City of Portland, Maine - Building or Use Permit Application

Permit No: 03-0120	Issue Date: MAR 25 2003	CBL: 083E A005001
-----------------------	----------------------------	----------------------

Location of Construction: 92 West Shore Dr - <i>Gettysburg Island</i>	Owner Name: Fitch, Ronald & Sandra	Owner Address: Diamond Avenue, CITY OF PORTLAND	Phone: 207-766-5886
Business Name:	Contractor Name: Owner	Contractor Address: Diamond Ave, GDI Portland	Phone: 2077665886
Lessee/Buyer's Name	Phone:	Permit Type: Additions - Dwellings	Zone: <i>IR4</i>

Proposed Project Description: *within*
Build 6,529 sq. Ft. Home *on* existing shell.

1 FIRST FLOOR PLAN  
A-1 3/16" = 1'-0"

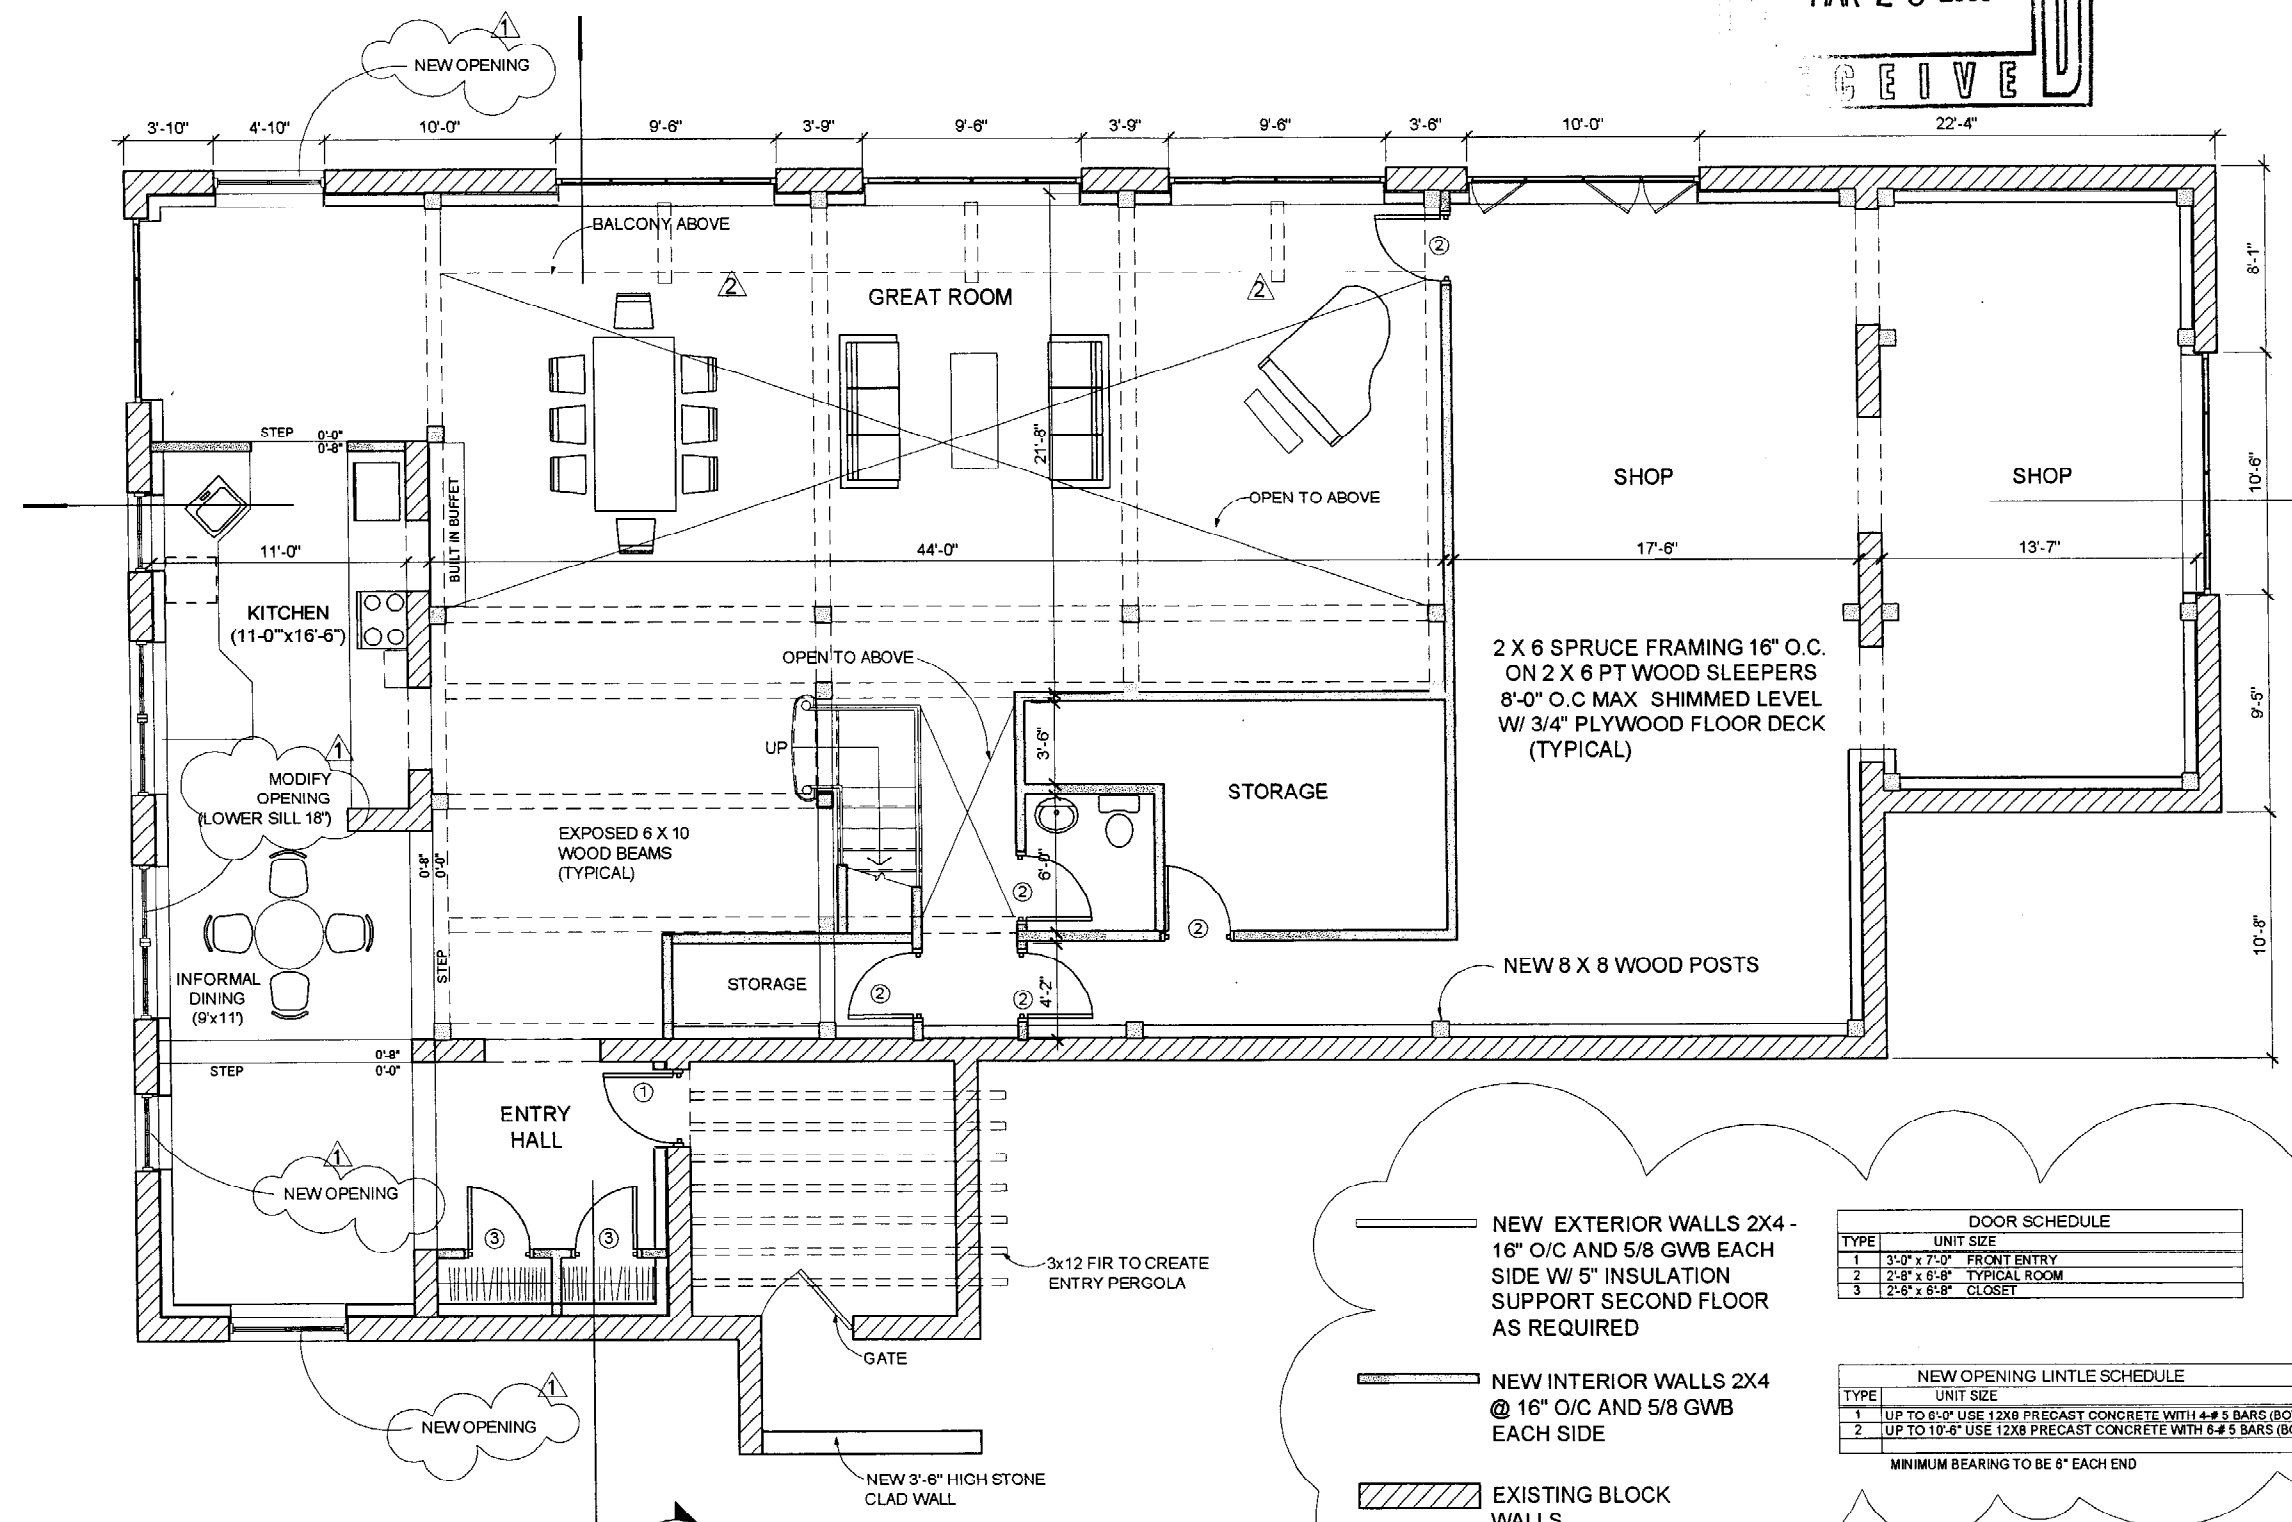
Dept: Building	Status: Approved with Conditions	Reviewer: Tammy Munson	Approval Date: 03/25/2003
Note: rec'd new plans - 03/25/2003 - discussed the following conditions w/ Scott Teas.	Ok to Issue: <input checked="" type="checkbox"/>		
<p>1) The lowest point of opening on egress windows must be 44" or less above the finished walking surface.</p> <p>2) Guardrails MUST be 36" minimum measured from the leading edge of the tread protecting all stairways.</p>

Comments:
3/11/03-tm: minimal structural details submitted - called designer Scott Teas @ 775-6141 AND LEFT MESSAGE
3/18/03-tm: rec'd additional plans - need stamped plans based on the design - precast concrete being use, post and beam construction, partially hanging balcony from roof. Called Scott Teas and spoke w/him.
3/21/03-tm: Spoke w/ Scott - need to stamp plans and address catwalk width(3'), guard heights and egress windows.
3/25/03-tm: rec'd new plans - ok to issue.
